Port Botany Industrial Estate (Southlands Remediation & Development Project - Stage 1)

S.75W Modification to MP08_0191

Response to Referrals / Department of Planning Queries

SITE PLAN- GROUND
1:750 @ A1
October 2014
4244_DA-02

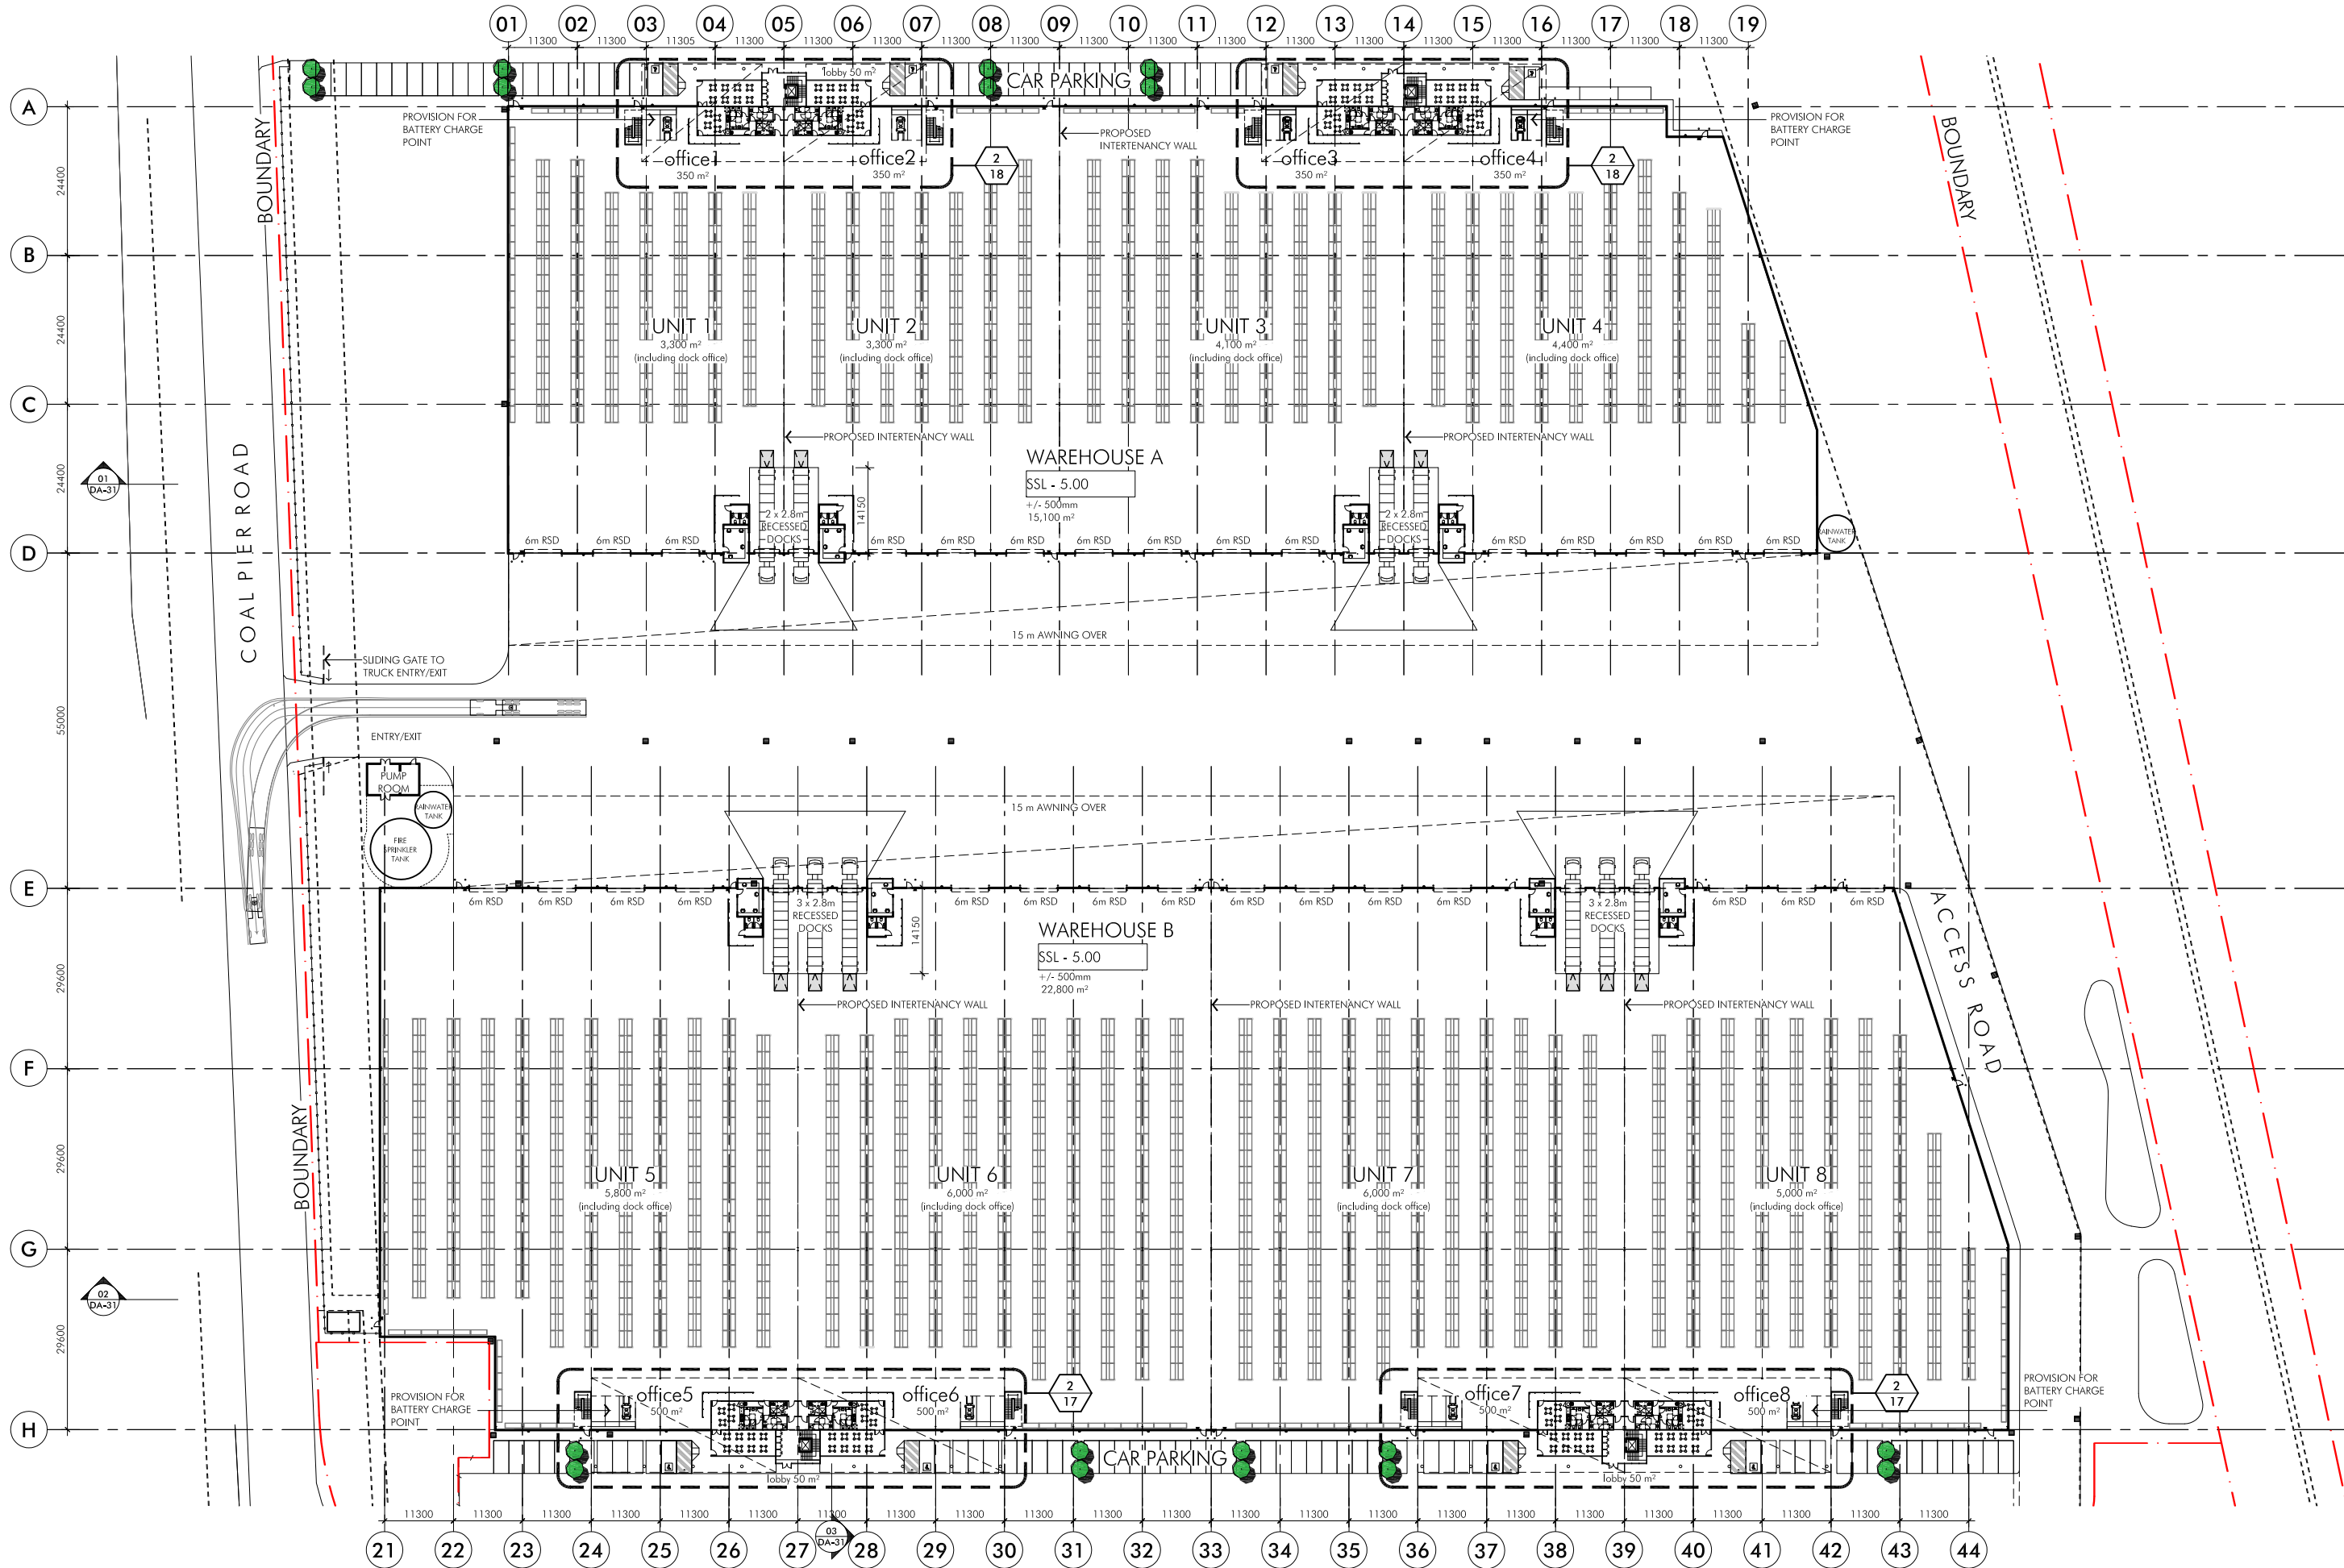
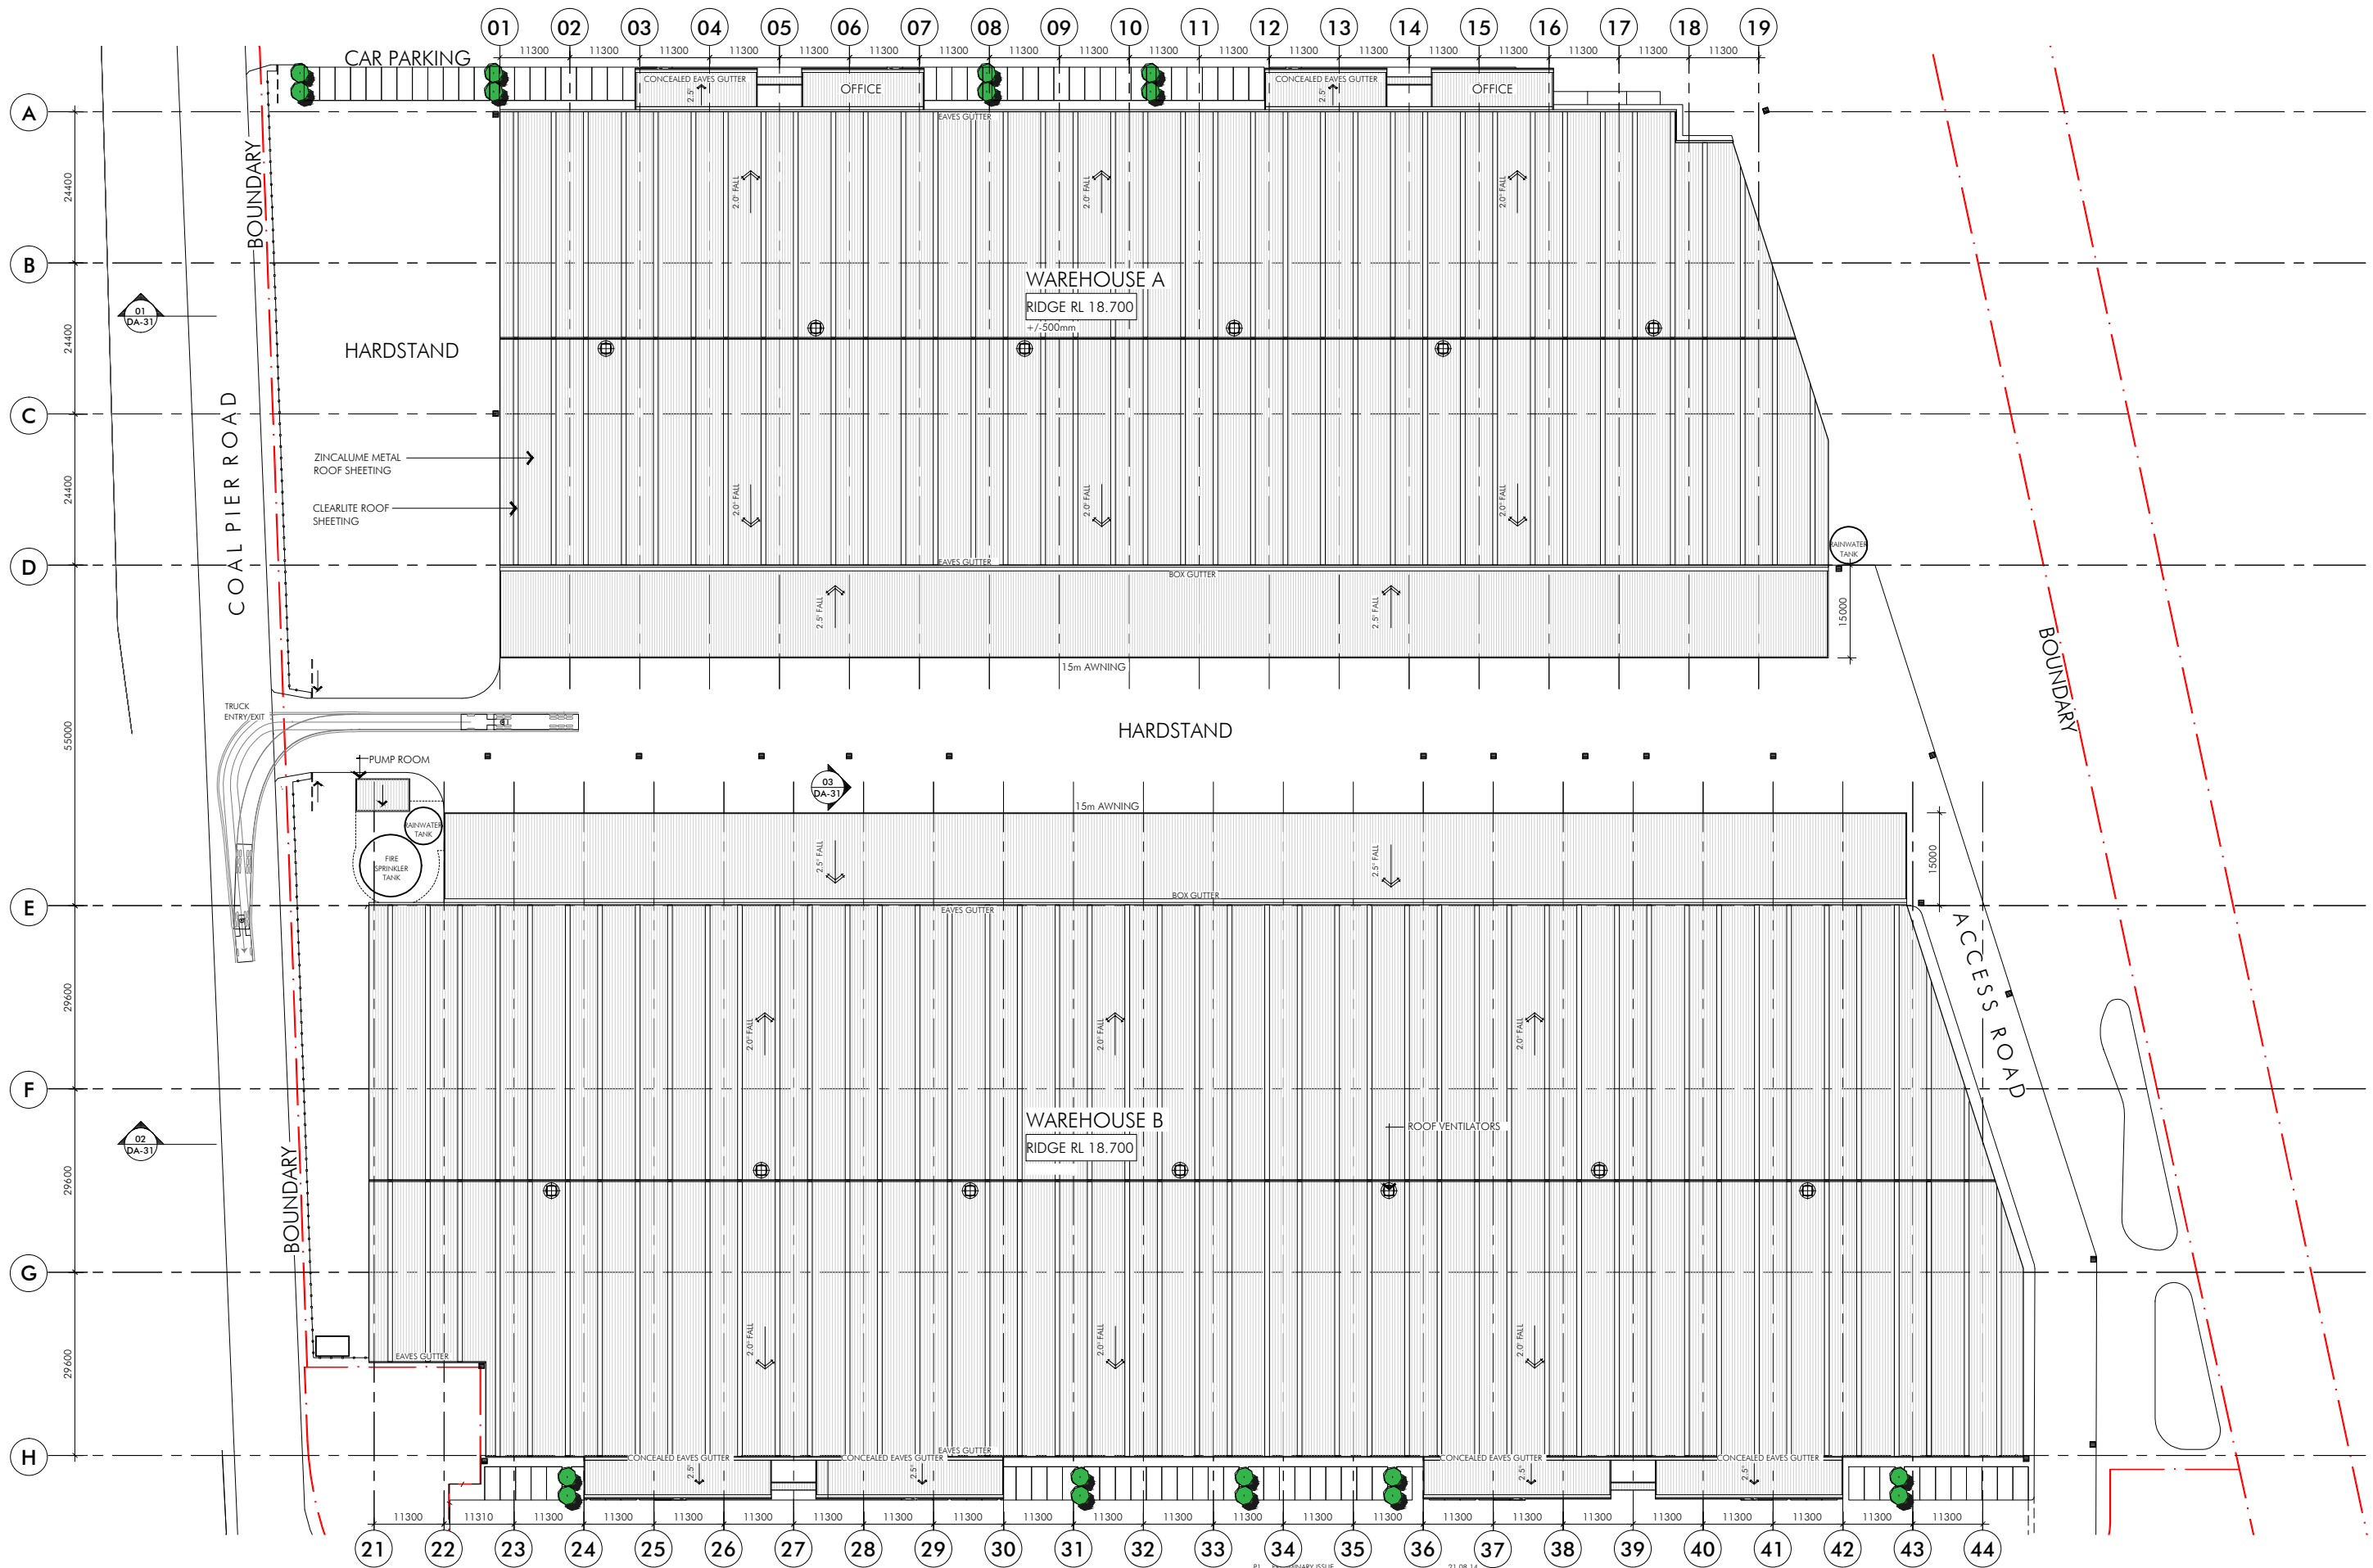
DoP Query / Comment	Response
Explain why the swept path analysis shows the median island on Hill Street.	The swept paths do not include swept path analysis for Hills Street.
Plans	
Figure 4244-DA-01 shows a strip of land to the west of Warehouse B to be flood detention, according to the approved plans this is incorrect, please amend.	Noted – this is an access easement and the plans have been updated to show this.
Please also note that (as the project approval covers the whole site and any plans included in the approval will replace the current plans) the revised drawing should show Lot 9 as flood detention.	Noted – the plans have been amended to show this.
Construction of the warehouses is described as being part of Stage 1 in the Project Approval. As such, please rename all plans as Stage 1 as per the currently approved plans.	Noted – plans have been renamed accordingly.
Roof Plan 4244_DA-12 shows the area to the west of warehouse A as hardstand, yet Master Plan 4244-DA-01 and landscape plan indicates that it will be landscaped. Please confirm which is correct and update the relevant plan.	Noted – Plan has been amended.
